CITY OF PORTLAND, MAINE
DEVELOPMENT REVIEW APPLICATION
PLANNING DEPARTMENT PROCESSING FORM

RE: C. of O. for #36 Salem Street,
(Id#2008-0026) (CBL 058 A 024001)

DATE: October 22, 2008

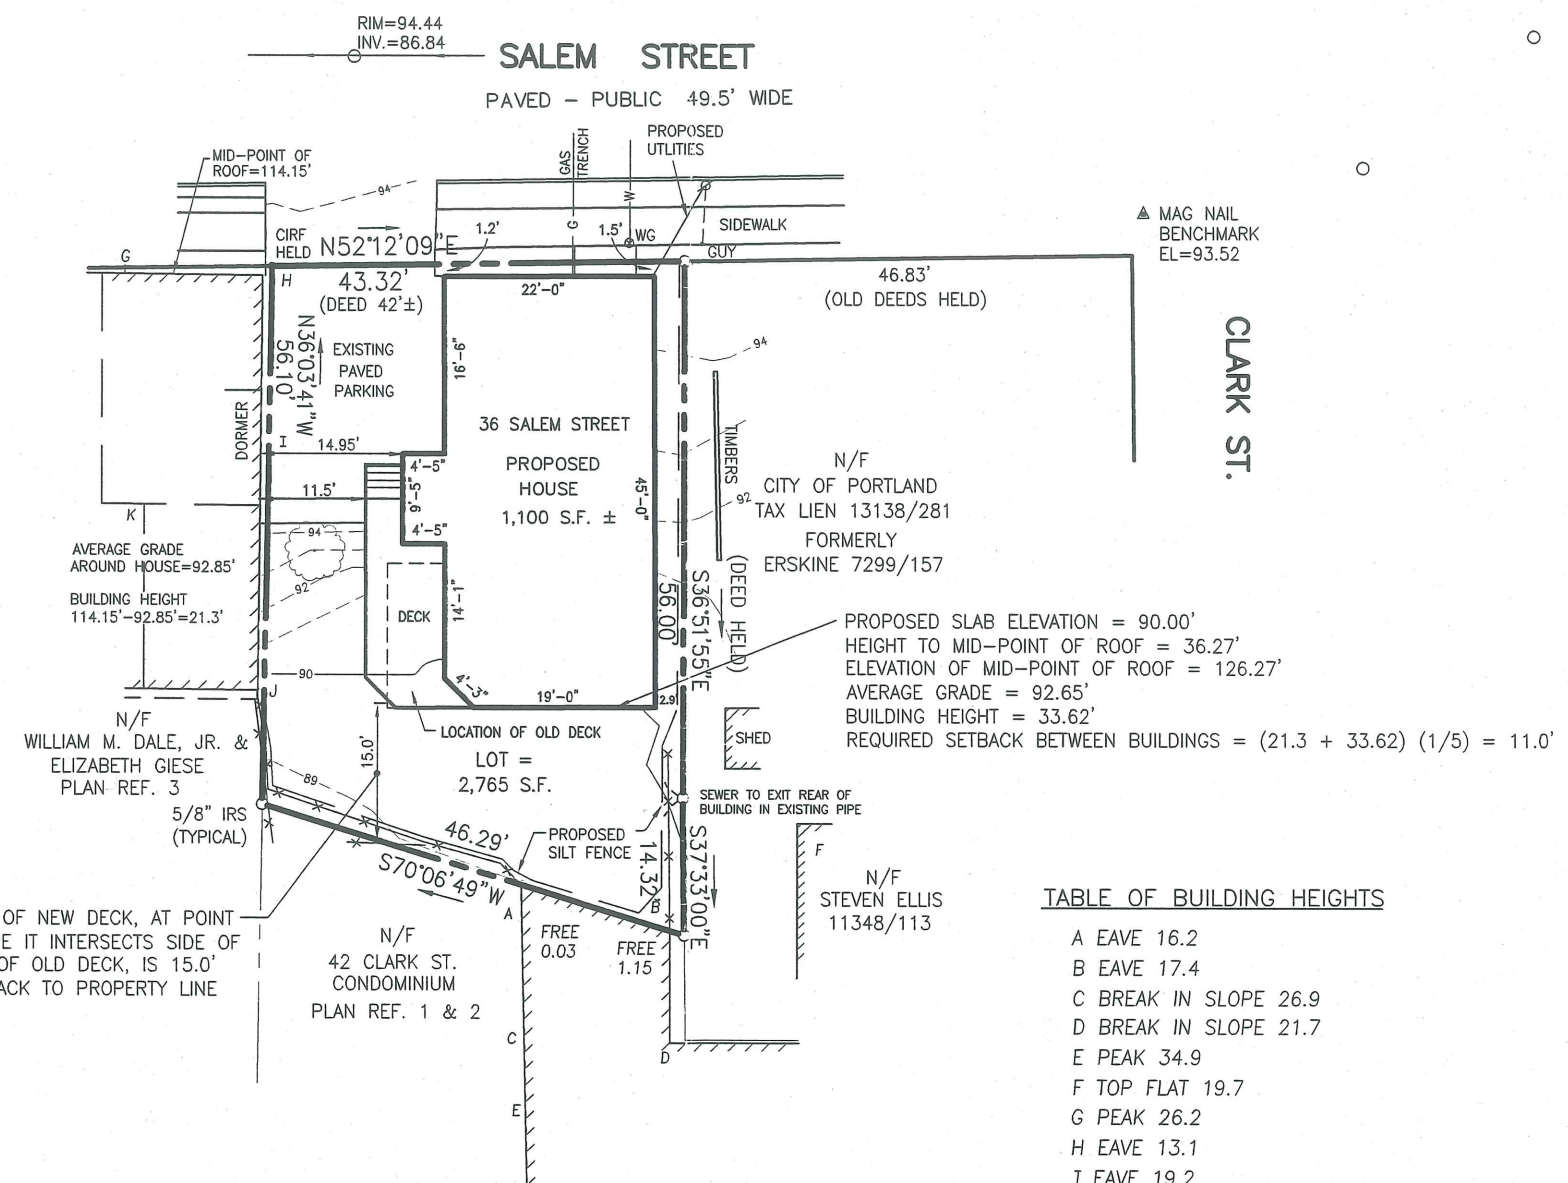
Site work incomplete:

1. Installation of all landscaping per the approved plan including trees, shrubs, flower beds, fence, stone patio and steps, loam and seed, etc.,

2. Condition 1 that the rear and side setback requirements are met for the deck.
